From: Laura Gibbons
Sent: 13 February 2019 15:09
To: 'James Massingham'
Cc: Laura Humphries; Yuved Bheenick (Linden Homes); Gareth Hardwick; Michael Eastham
Subject: RE: Walberton - Today's Development Team Meeting

Thank you for sending through the additional information. I have the following comments:

PRIVATE MANHOLE TYPE A
(DEPTH FROM COVER LEVEL TO SOFFIT OF PIPE 3.0-6.0m)

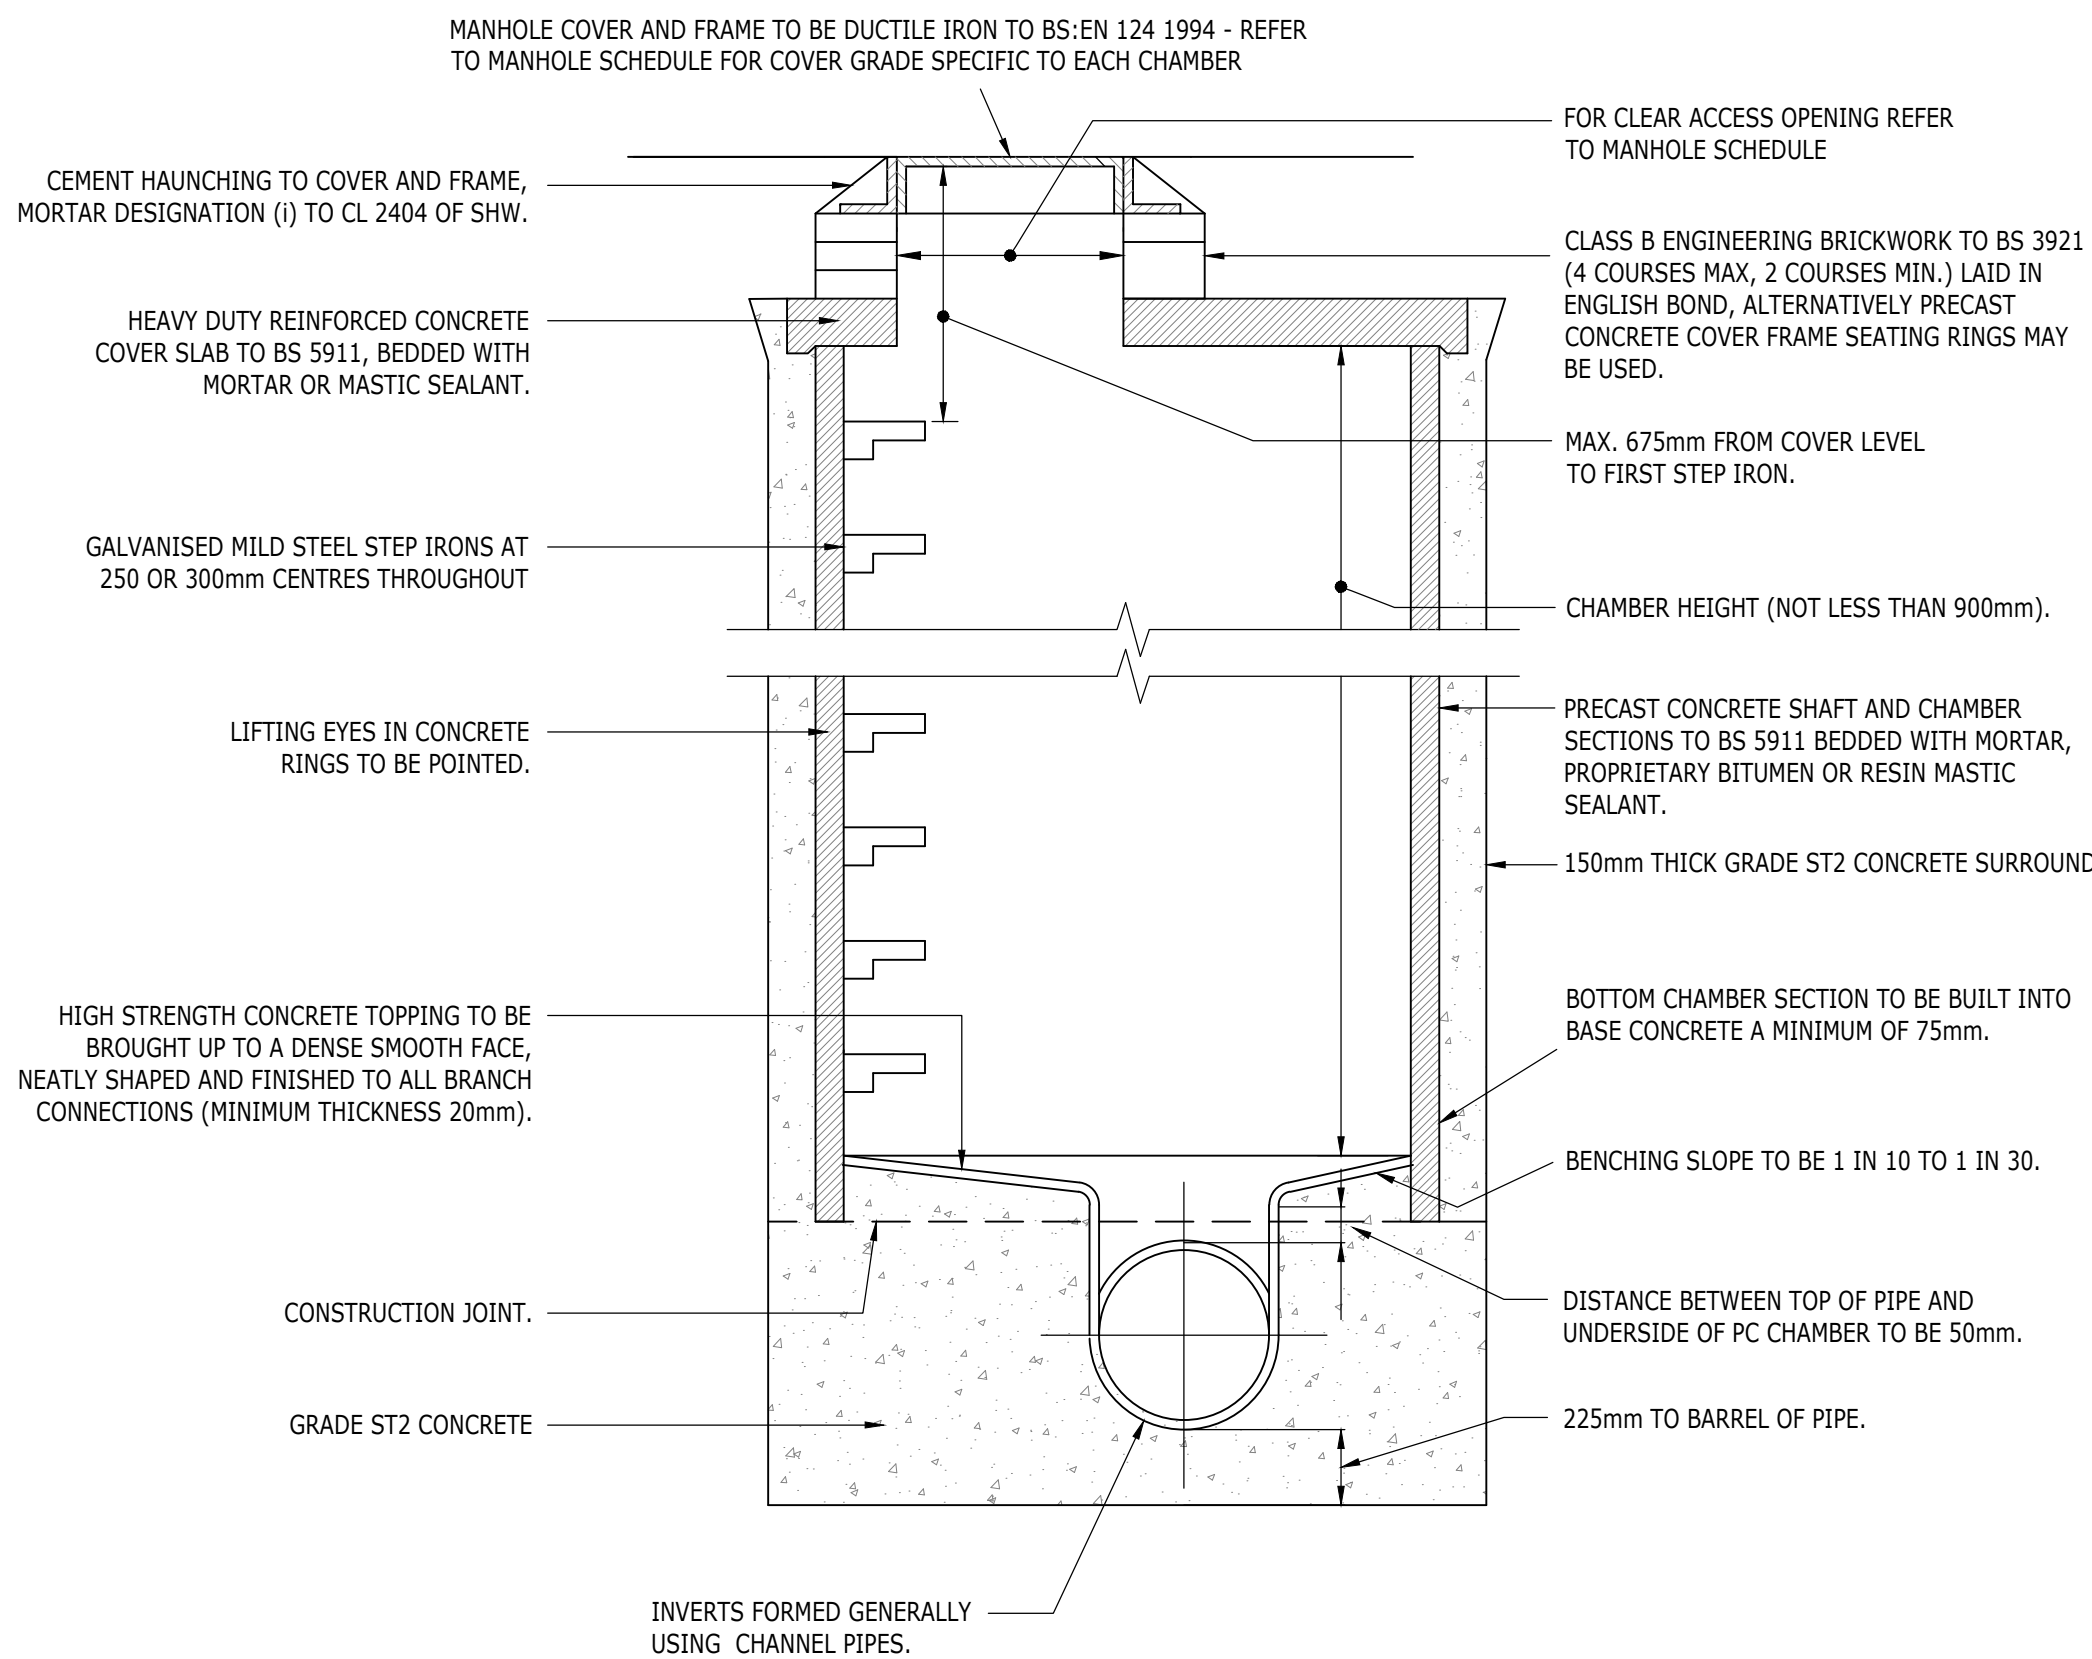
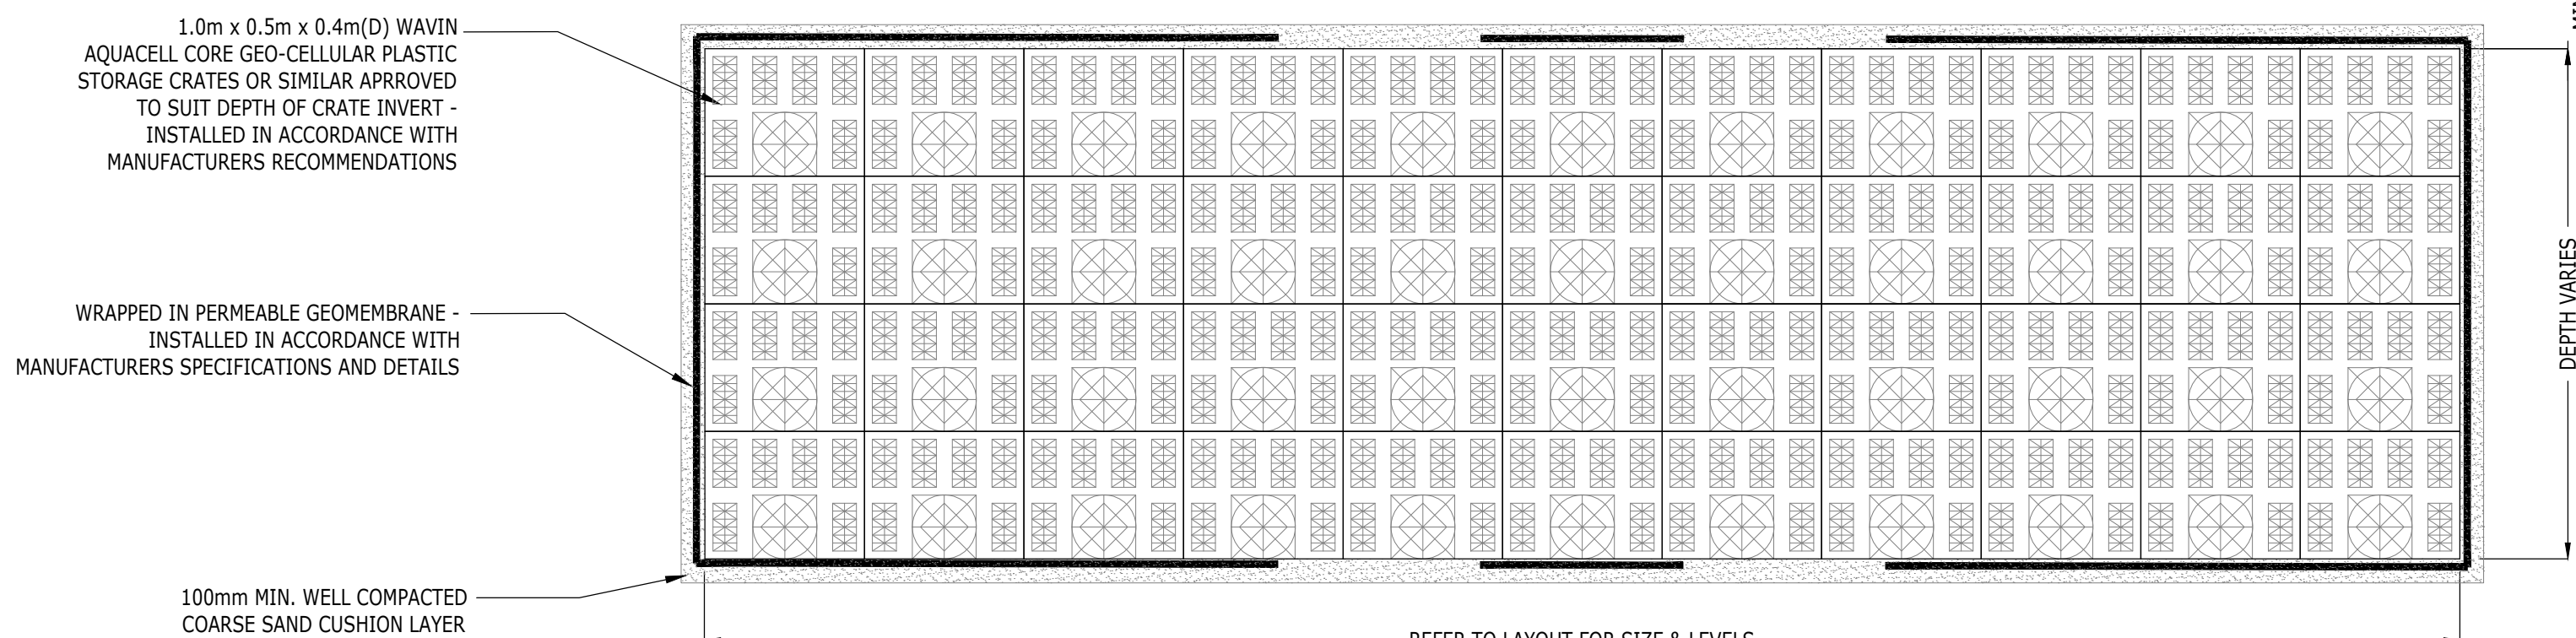
19. Please provide construction details for catchpit manhole.
20. Please provide a manhole schedule.
